Architecture and Landscape Section 4.55 Modification  
Port Macquarie Campus

Project	Hastings Secondary College	Code	HSPM
Organisation	FJMT	Revision	1
To	Bill Rushworth	Date	14/04/2022
		Doc Number	A-000055

scale	1:200 @ A1	first issued	12/2/21
project code	HSPM	sheet no.	SSDA-310101
		revision	05

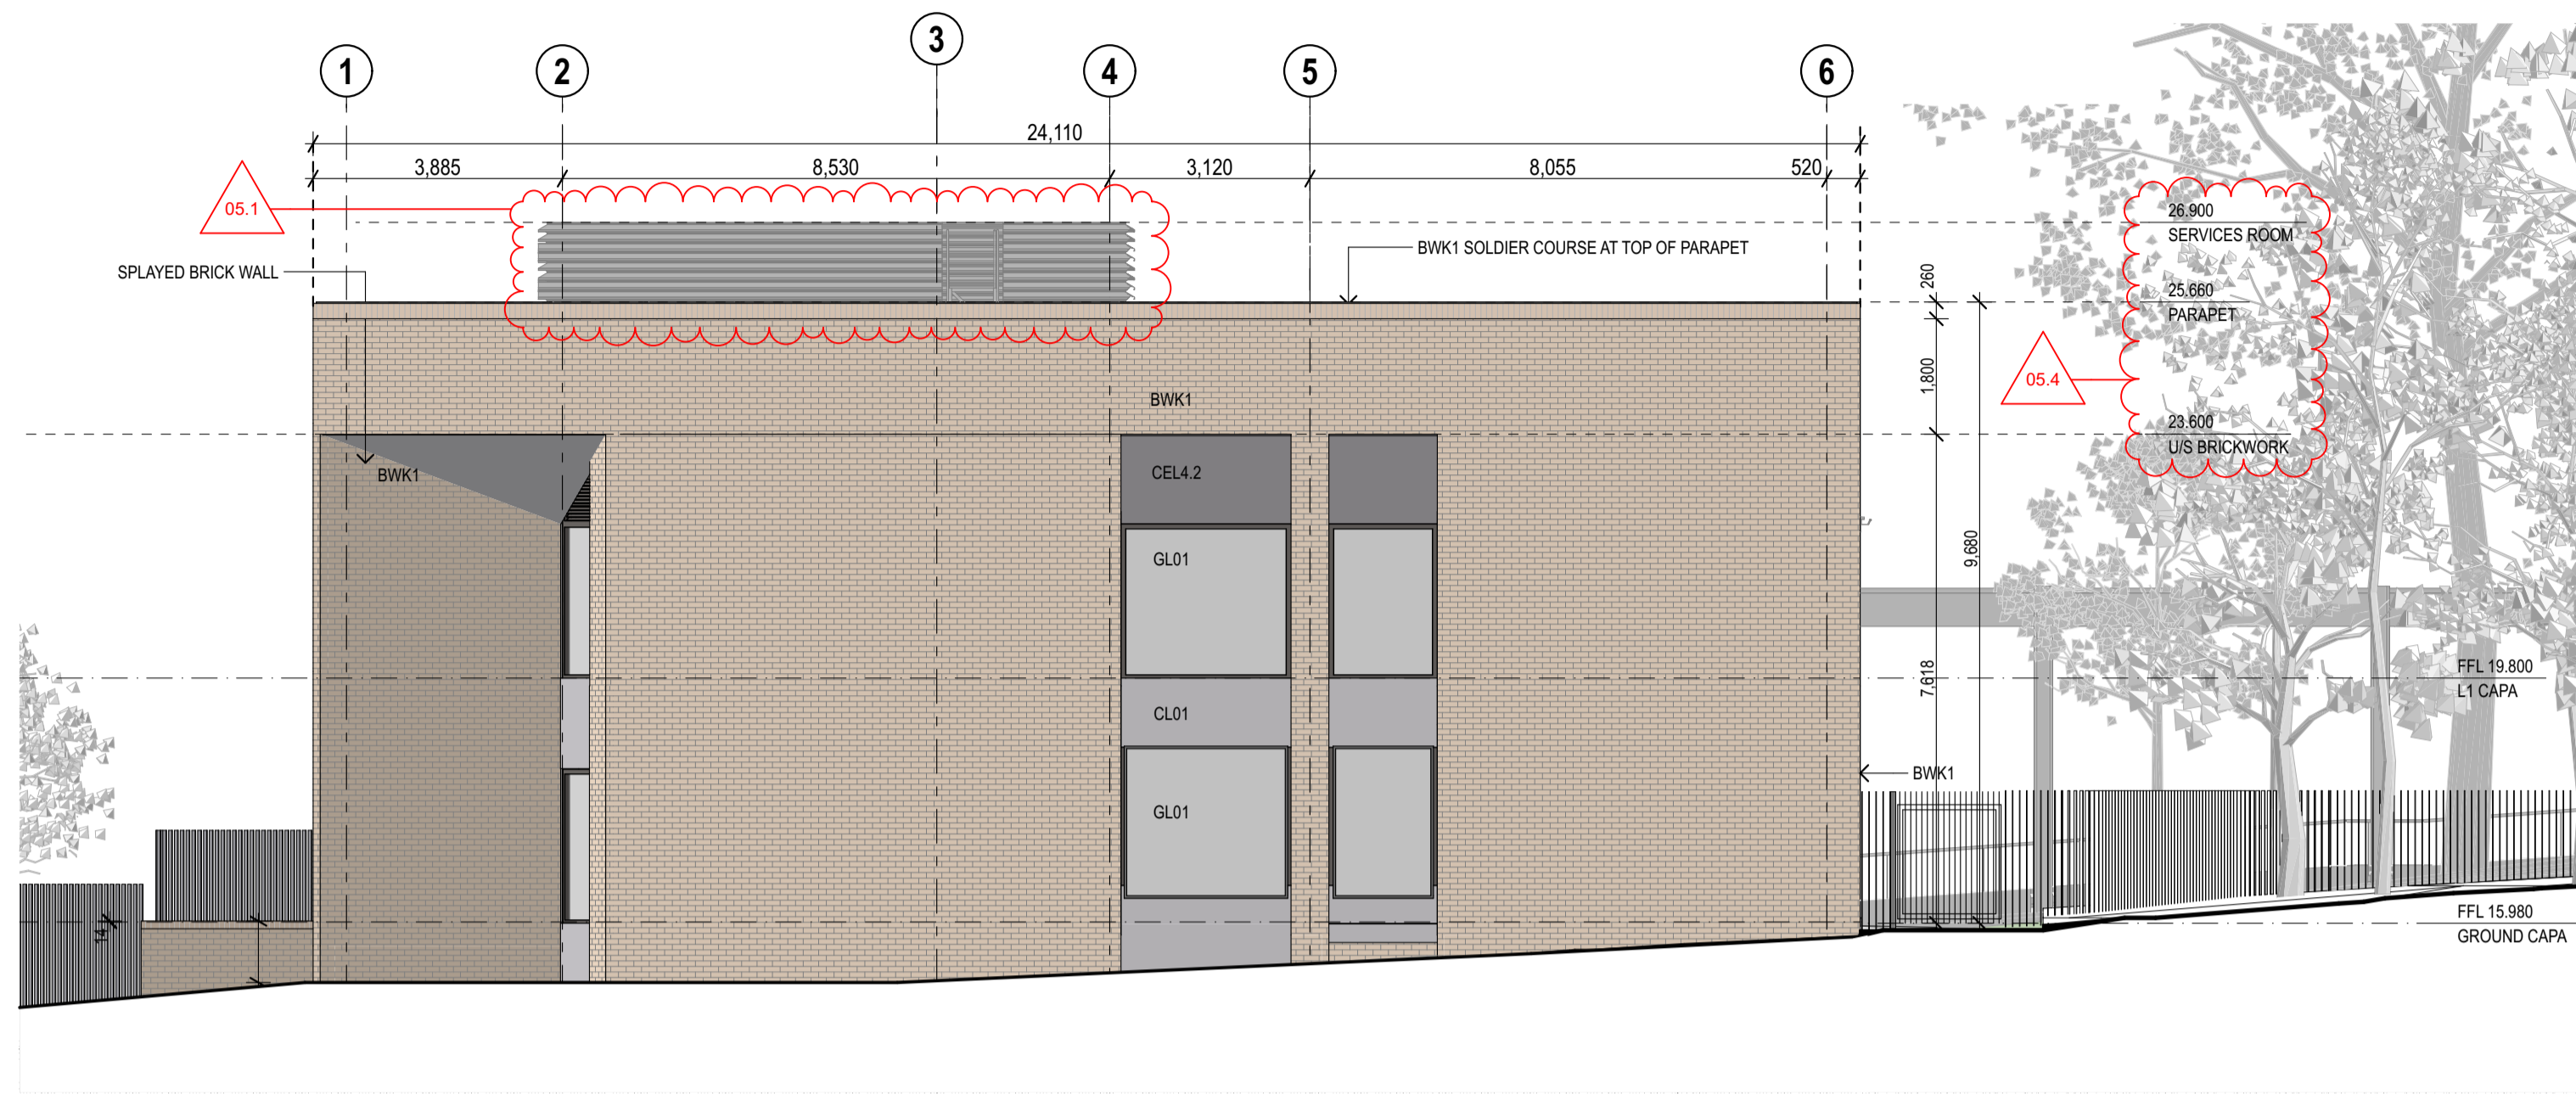
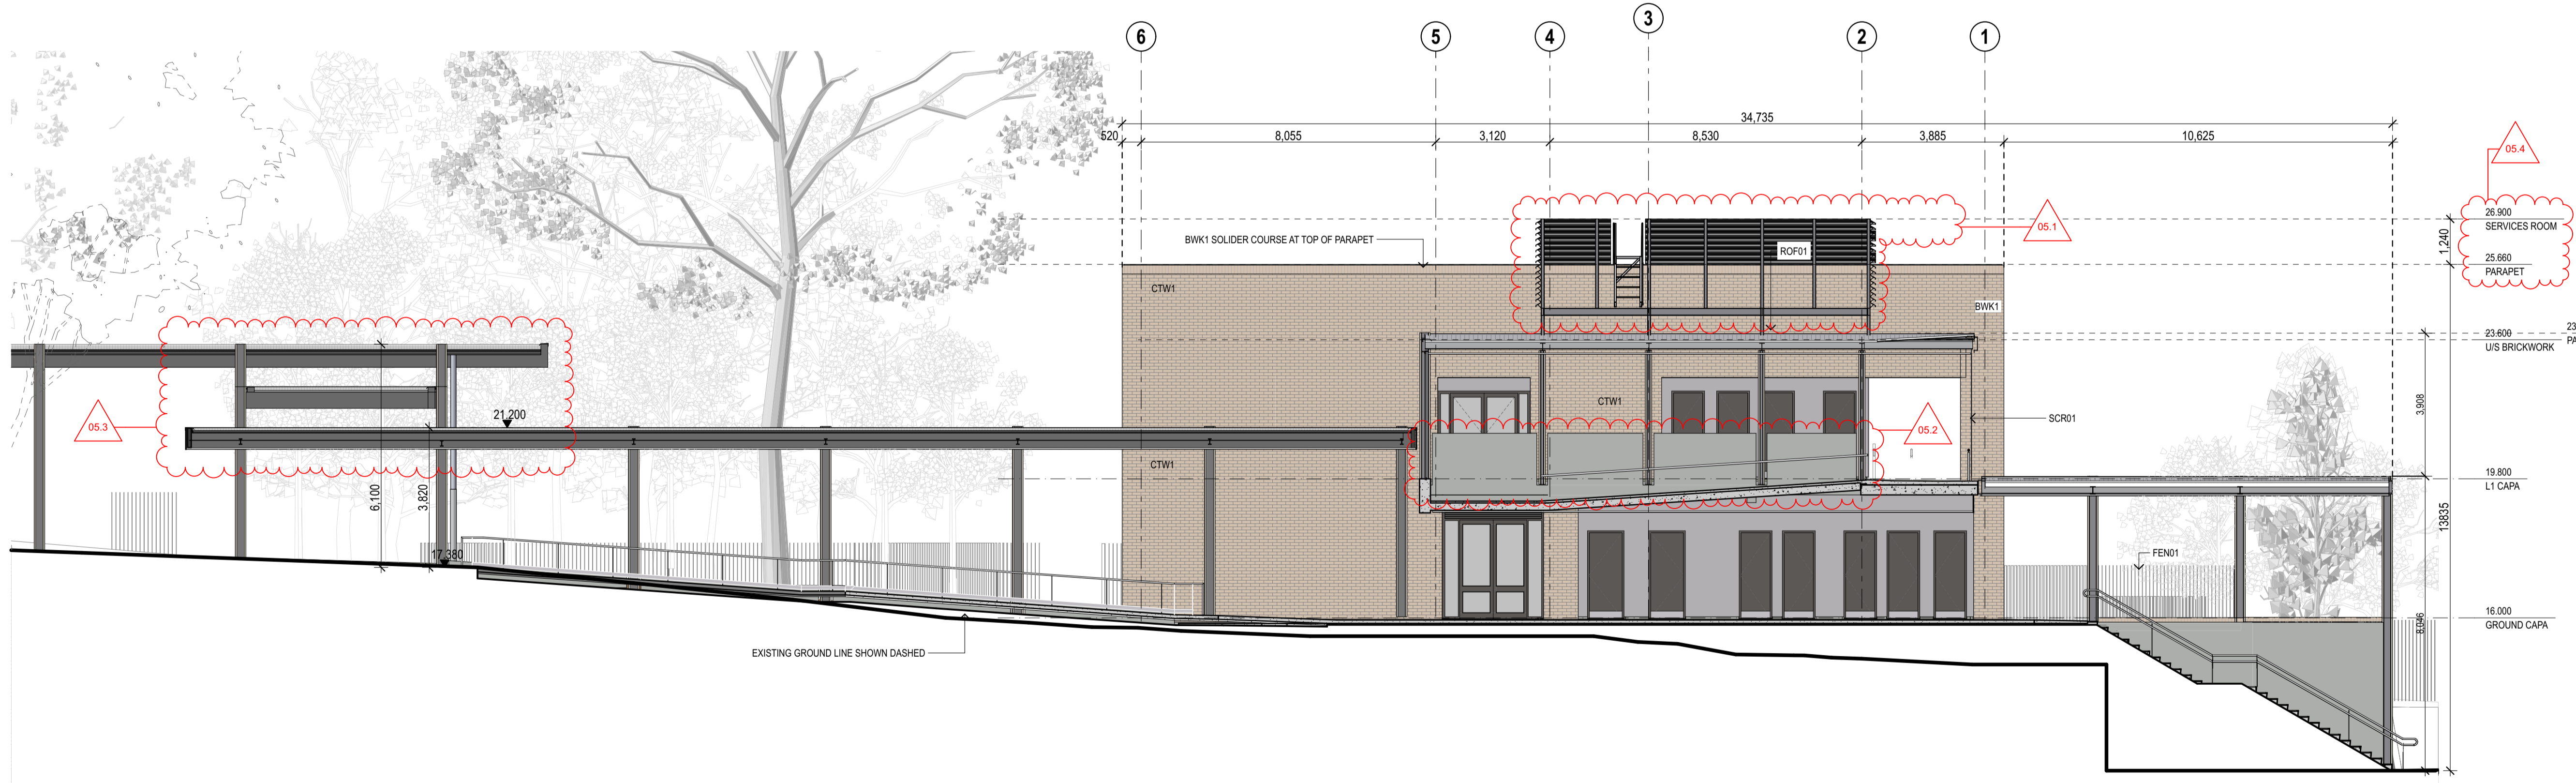
5.4	Overall height of parapet refined to meet brick dimensions and final co ordination. (Lowered)
			5.5	Addition of Louvre to Kiln Room
SSDA-310101	05	Elevations - CAPA East & West	5.1	Further co ordination and resolution of external plant.

5.2	Further resolution and co ordination of ramped access to Building B to meet code requirements and DoE brief requirements (width)
			5.3	Revision to entrance to provide a simpler canopy and a more equitable response to the Main Entrance. The canopy is held back from the existing porch roof which is maintained.

5.4	Overall height of parapet refined to meet brick dimensions and final co ordination. (Lowered)
SSDA-310102	04	Elevations - Building L	4.1	Update to extent of Building B and Building L linkway, existing walls to be retained where possible.
420000 1:200 Sections				
SSDA-420100	05	Site Sections	5.1	Revision to entrance to provide a simpler canopy and a more equitable response to the Main Entrance. The canopy is held back from the existing porch roof which is maintained.
